**CITY OF PORTLAND**

October 7, 2004

RE: Frontage of lot at 456 Capisic Street – 258-B-002 & 259-C-20 – R-3 Zone

EXISTING CONDITIONS/ SITE PLAN
456 CAPSIC STREET PORTLAND, MAINE

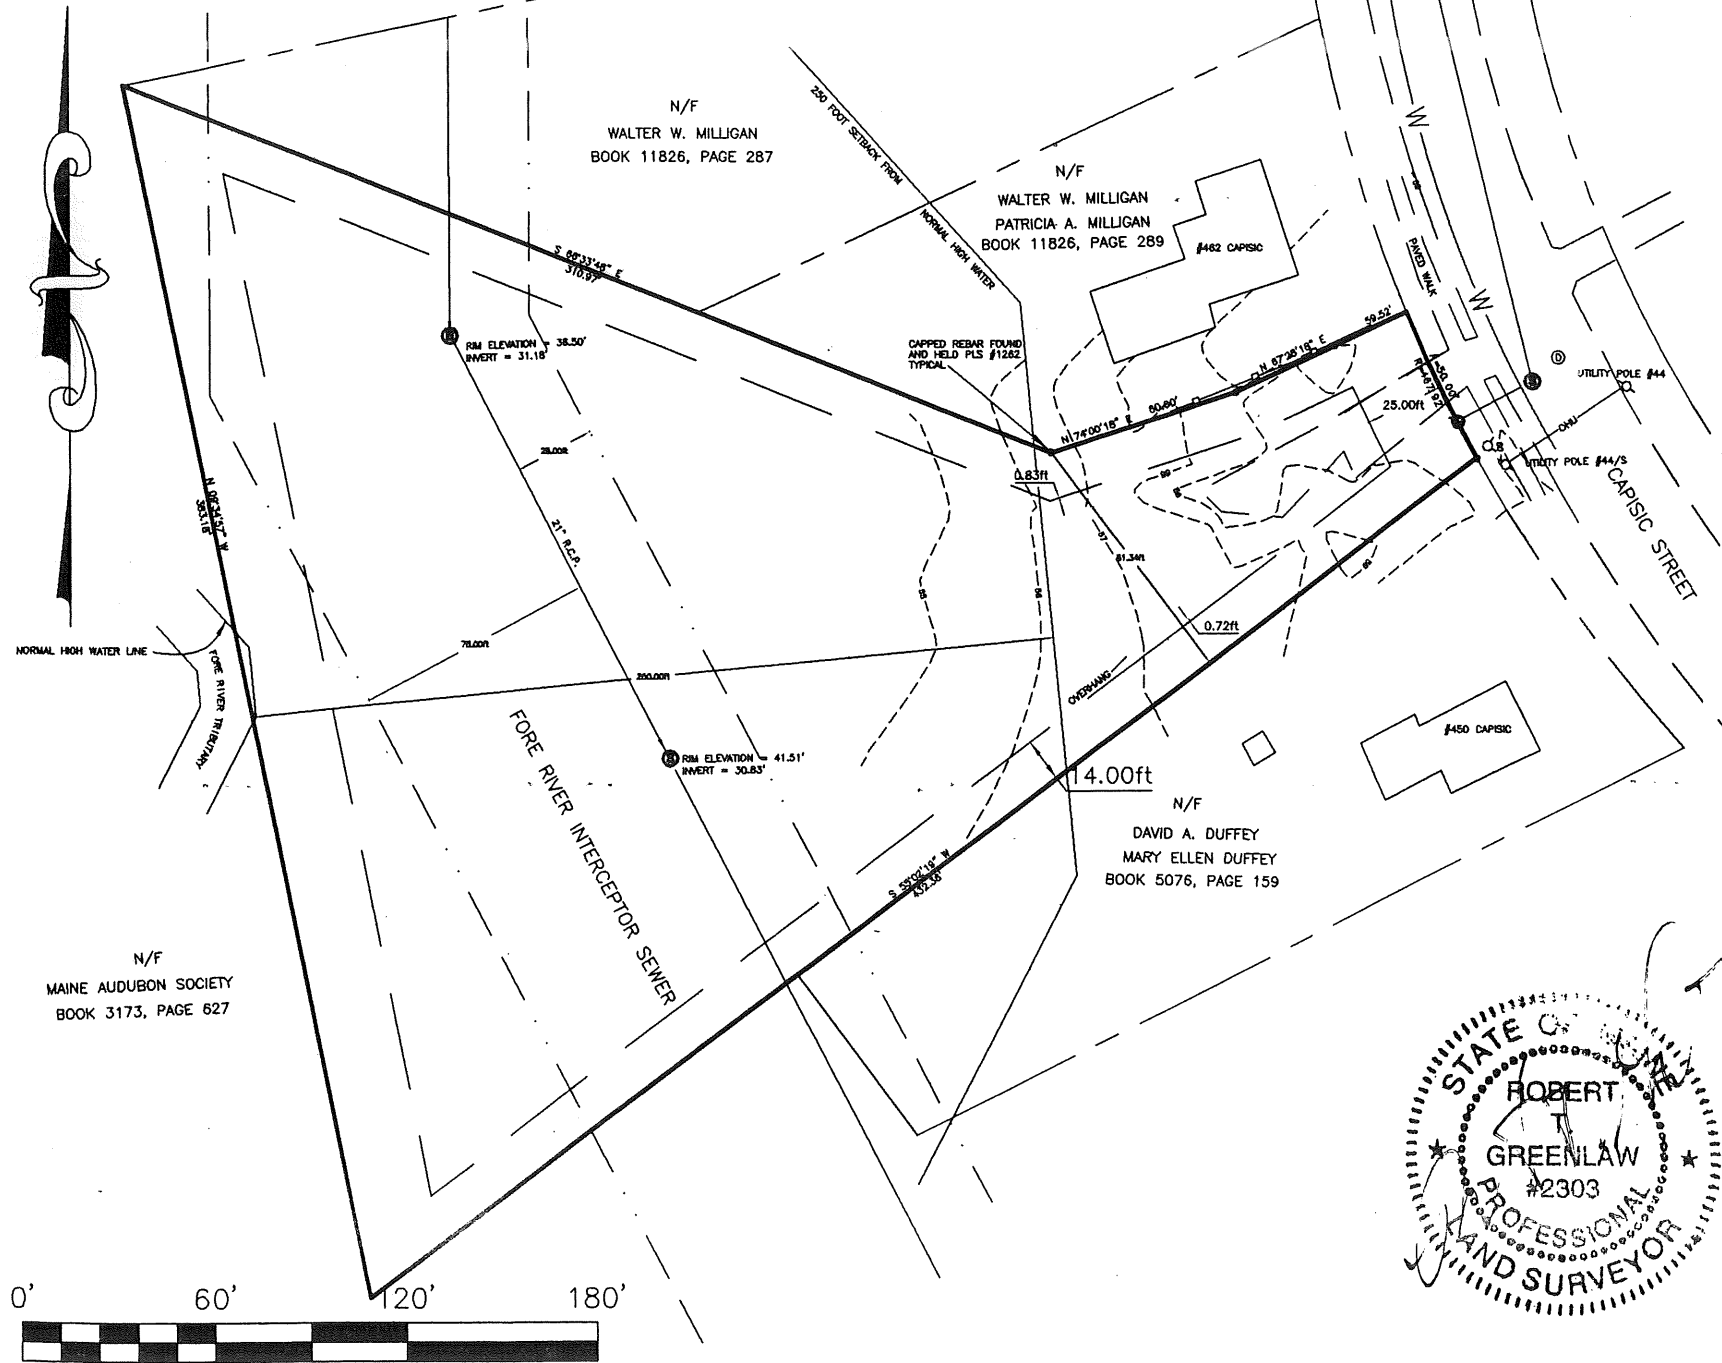
This will confirm that I have reviewed a survey plan entitled 'Plan of Property 462 Capisic Street Portland Maine made from eps Enterprises' by R.P. Titcomb Associates, dated July 28, 1987.' This survey shows the front of the lot to be on a slight curve. Since the actual front lot line of the property is part of a curve, that would be what is measured for compliance. The given 50.001 feet is the amount of frontage shown on Capisic Street. The R-3 zone requirement of a minimum of 50 feet street frontage is being met according to this survey.
